RE: The Reserve at Corral Bluffs Fil 5 (SF2012) – DWR Subdivision File 27158

RE: The Reserves at Corral Bluffs (Filing 5)
Section 31 T13S, R64W, 6th P.M.
Water Division 2, Water District 10
Upper Black Squirrel Creek Designated Basin

THE RESERVE AT CORRAL BLUFFS FILING NO. 5

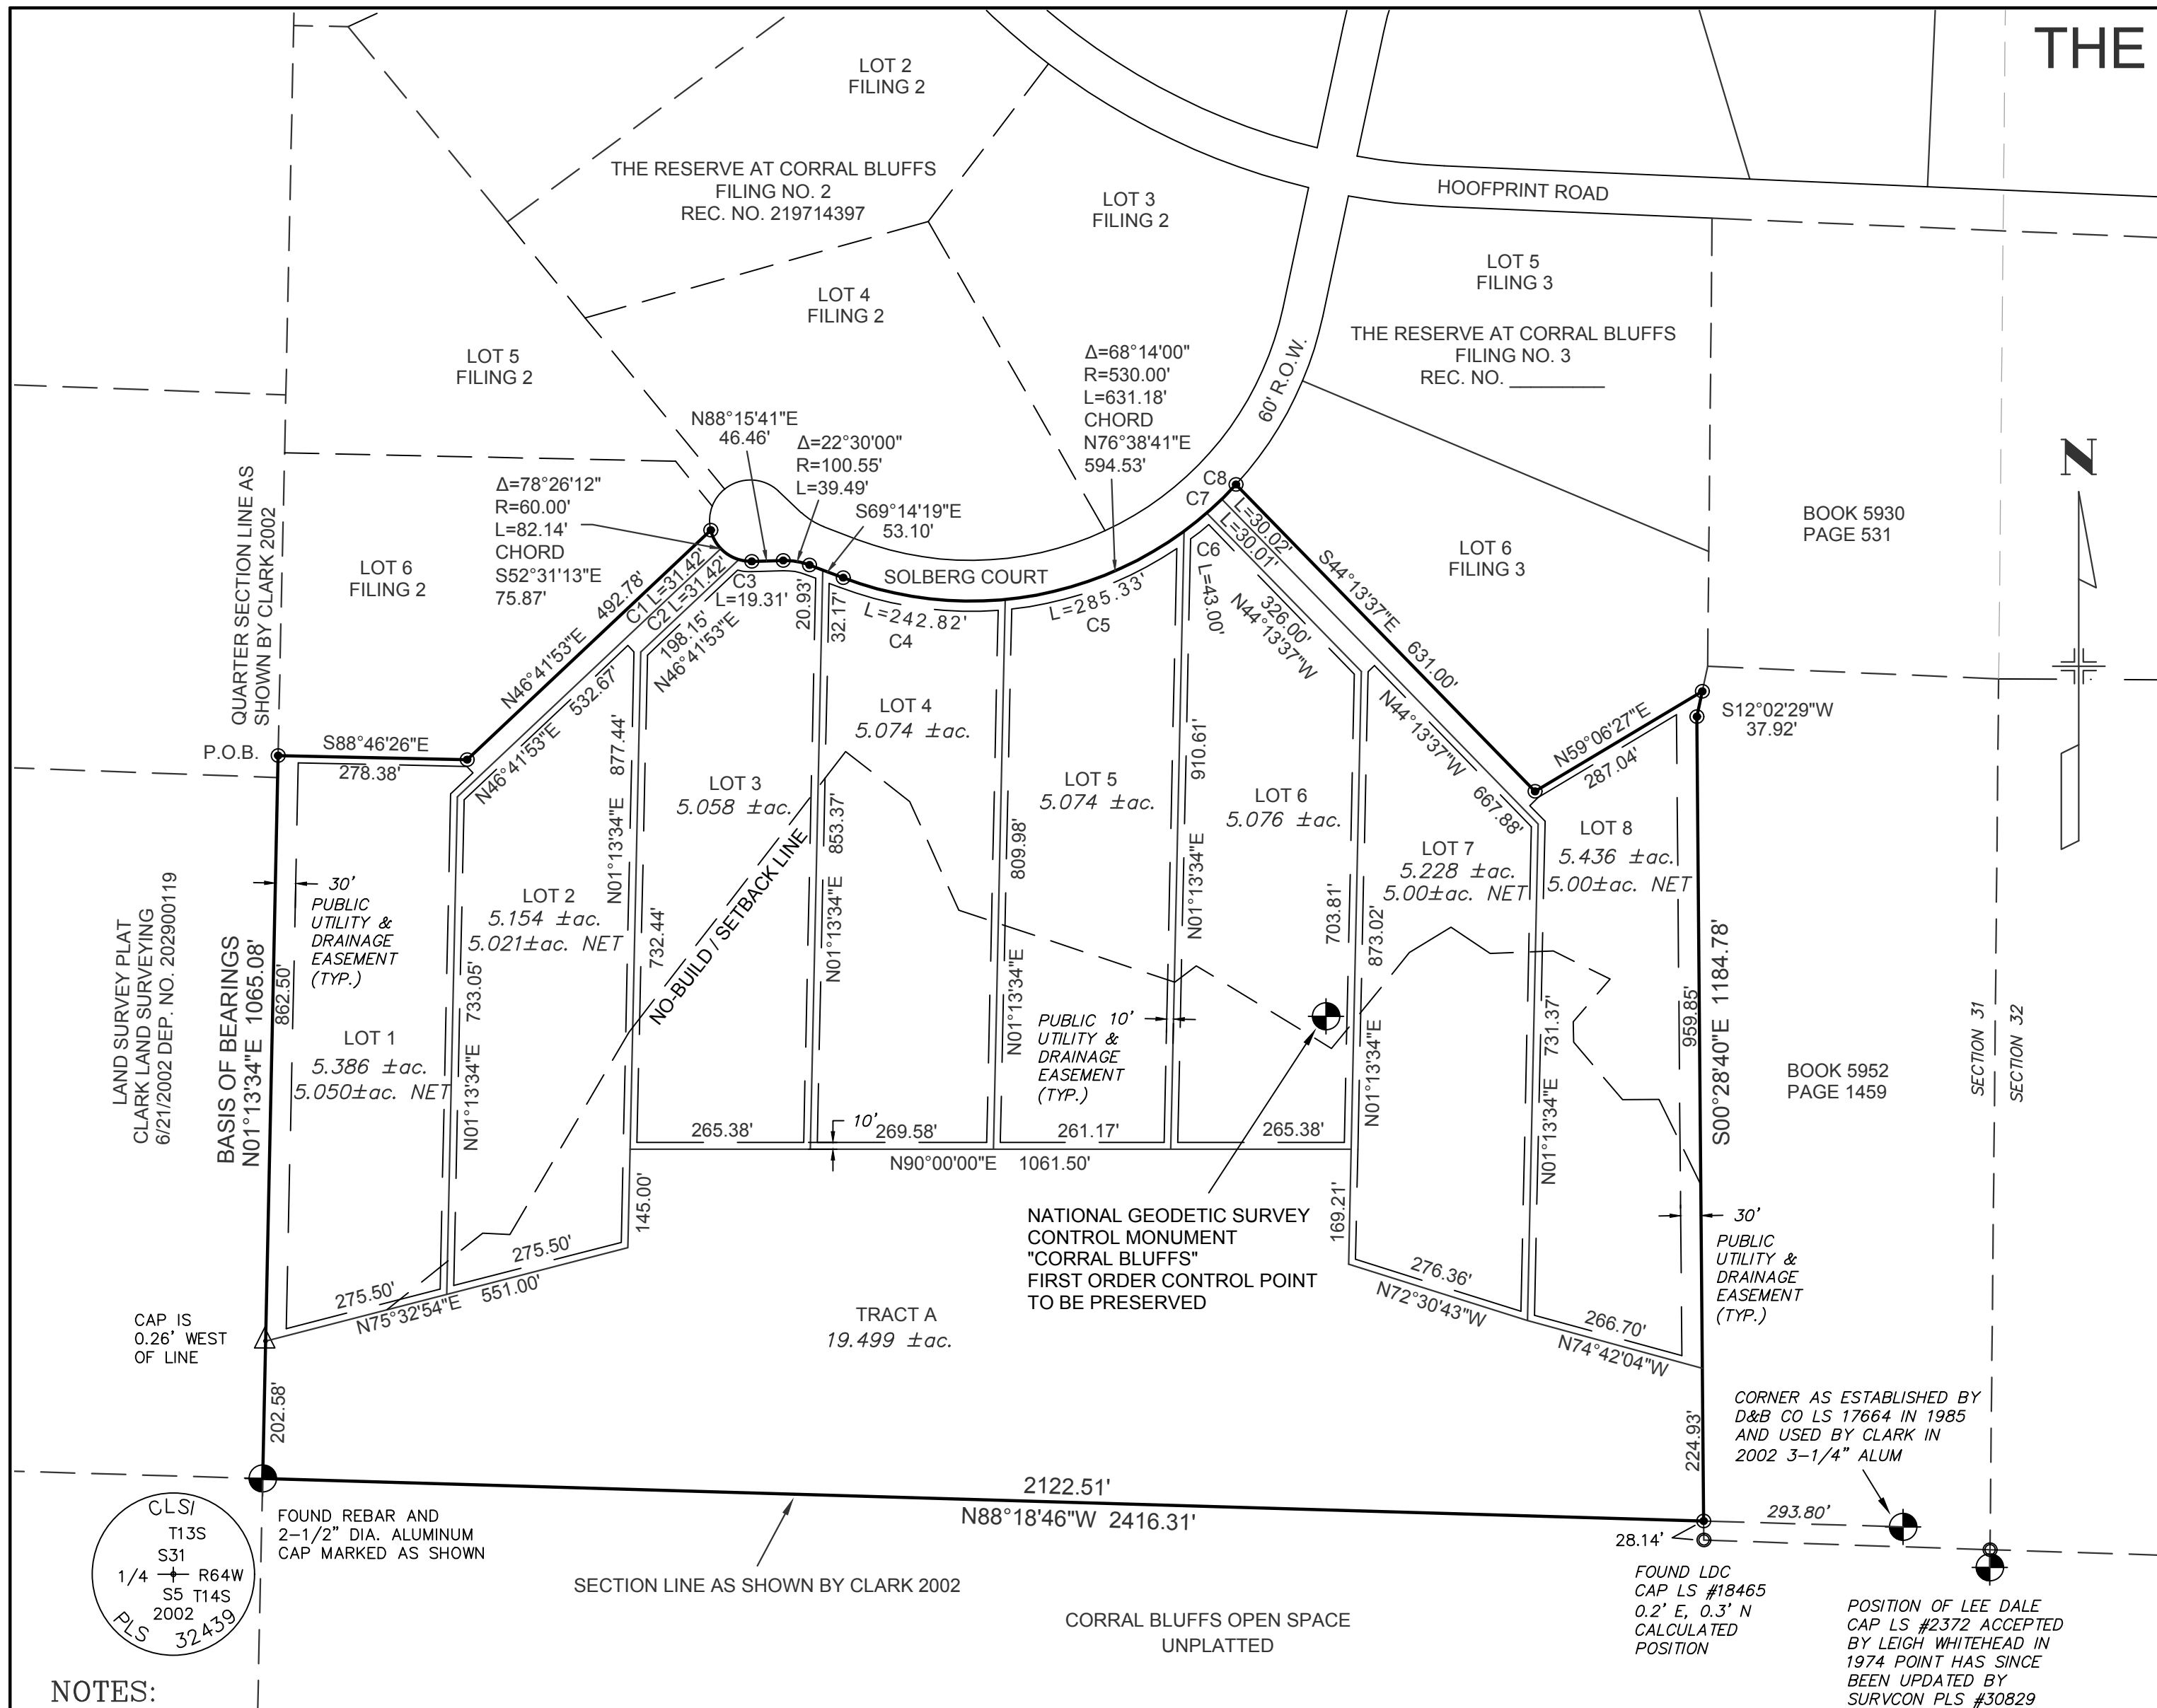
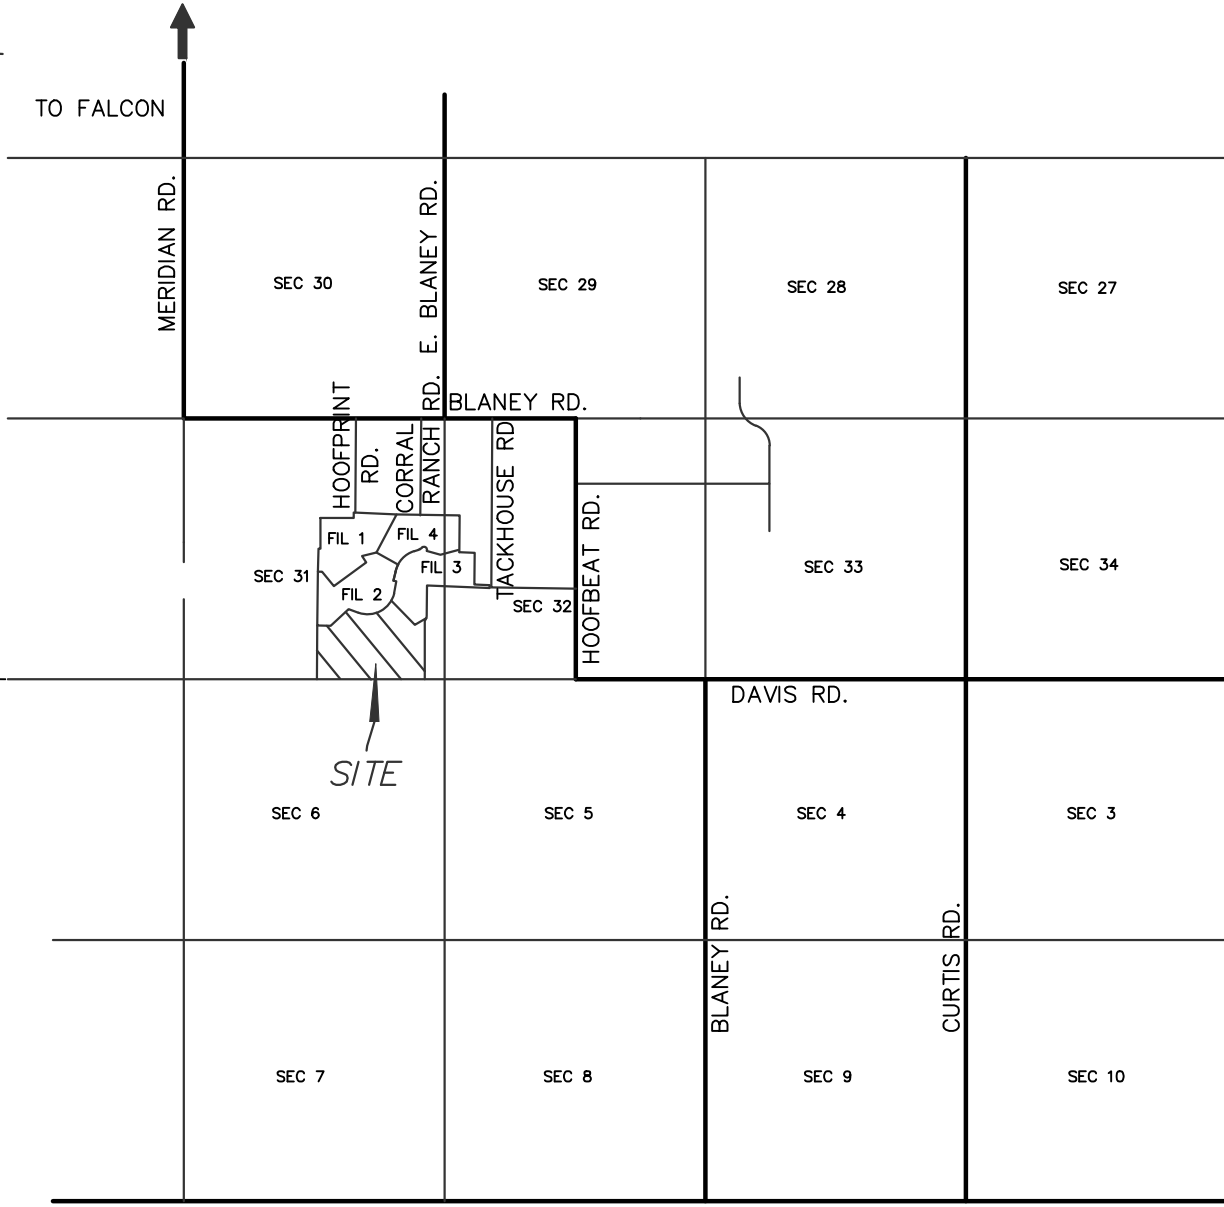
1. The developer must specify which lots will be required to seek Arapahoe aquifer wells (10 lots minimum for the entire Corral Bluffs development) and which lots can seek wells in either the Denver or Arapahoe aquifer (21 lots maximum for the entire Corral Bluffs development).

Filing 5, the subject of your review letter, contains 8 Lots. We have modified and resubmitted the subdivision documents to limit all 8 lots within Filing 5 lots to Arapahoe aquifer wells. These revised subdivision documents are included with the EDARP document system which I believe were transmitted to you by Mr. Howser and include;

- Final Plat – The reserve at Corral Bluffs Subdivision Fil 5. Reference Plat Note No. 9 which states “All lots within this subdivision are restricted to Arapahoe aquifer well permits only.”
- Water Supply Information Summary – Reference Section 10, Water Supply Source has been revised to include New Wells – in Upper and Lower Arapahoe only.
- Third Amendment to Declaration of Convents, Conditions, Restrictions and Easements for the Reserve at Corral Bluffs Filing No. 2 – Reference Exhibit A which brings the 8 Filing 5 lots into the into the Reserve at Corral Bluffs Homeowners Association and Amendment 2.4 which states in part “Notwithstanding any other provision of the Declaration, as amended, all lots in Filing No. 5 are restricted to Arapahoe aquifer well permits only.”
